Application for approval of reserved matters following outline application LU/355/10 for the appearance, landscaping, layout and scale of 70 dwellings (including 20 affordable dwellings) within land parcel 1B. Departure from the Development Plan.

Land Parcel 1B Courtwick Lane Land south of Railway Littlehampton

Thank you for your internet comments made on 19th September 2013 which has been recorded as **'an objection'** with the comments as follows:

Rev.	Date	Description	Scale	Drawn	Checked
Client			1:100 @ A3	MCN	DGP
Project			Date	File	
Courtwick			July 2013	Garages	
Littlehampton					
Drawing Title			Drg.No.	Rev.	Drawing Status
8 Garage Block			P802/GAR/05	-	PLANNING
Floor & Roof Plans

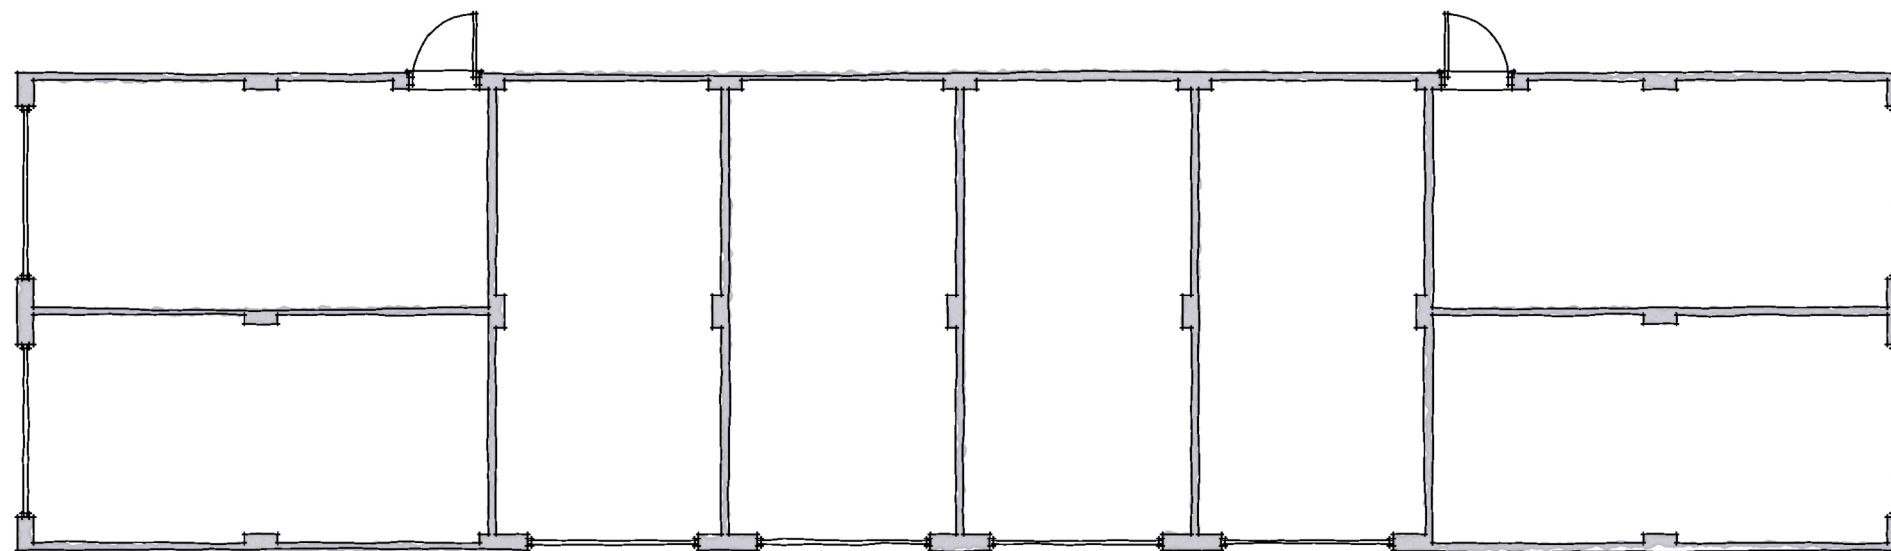
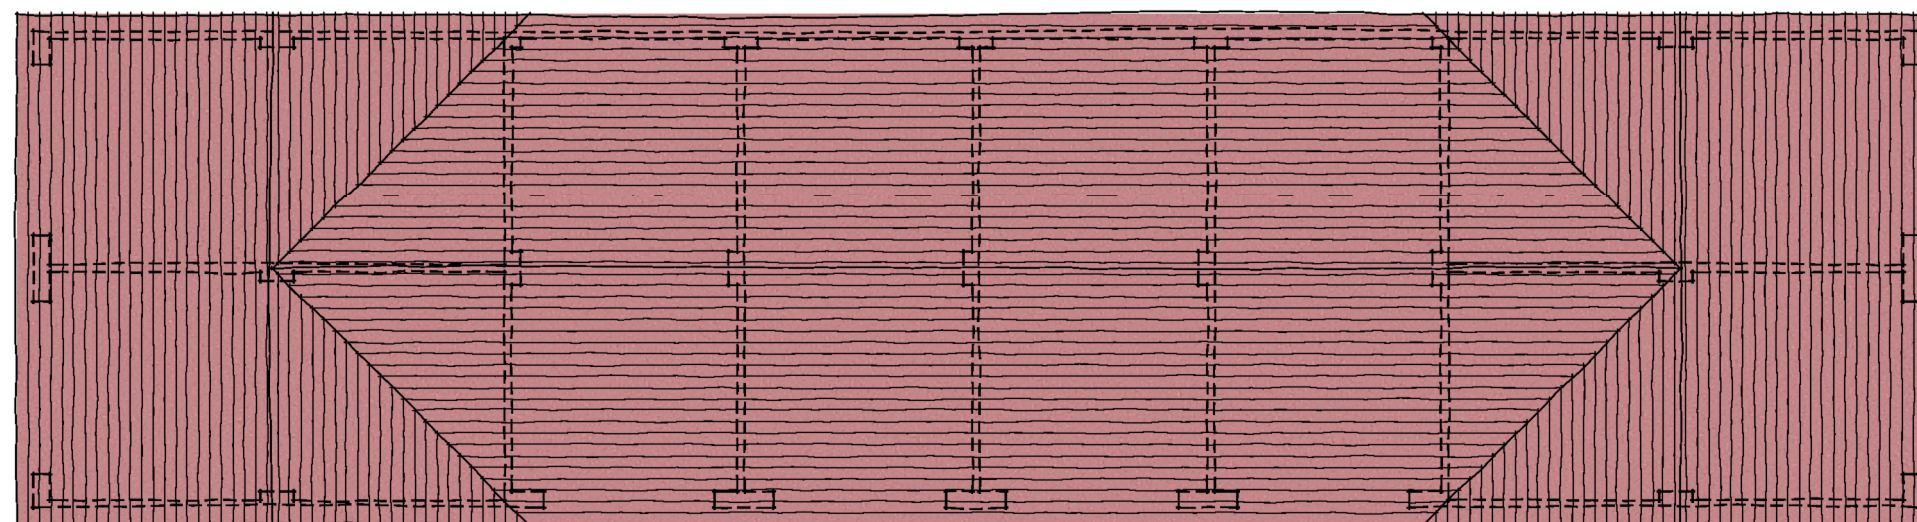
The Town Council object to the proposed design of the development at this site and maintains its objection to the scheme on the grounds that it fails to meet the requirements of the National Planning Policy Framework in terms of housing supply and good design. Whilst Members recognised that the developer had made an effort to address some of the concerns previously expressed by this Council regarding the unimaginative design, issues remained. The plan lacked any soft landscaping, front gardens and green spaces. Members wished to see more careful consideration of the planting on the estate. The extent to which the design of the estate relied on hard surfaces also gave rise to serious concerns about the impact of water run-off, the provision of drainage and flood prevention measures in general given that the estate is close to the flood plain. Members were especially concerned about parking and questioned if the size of the garages was sufficient to alleviate on-street parking.
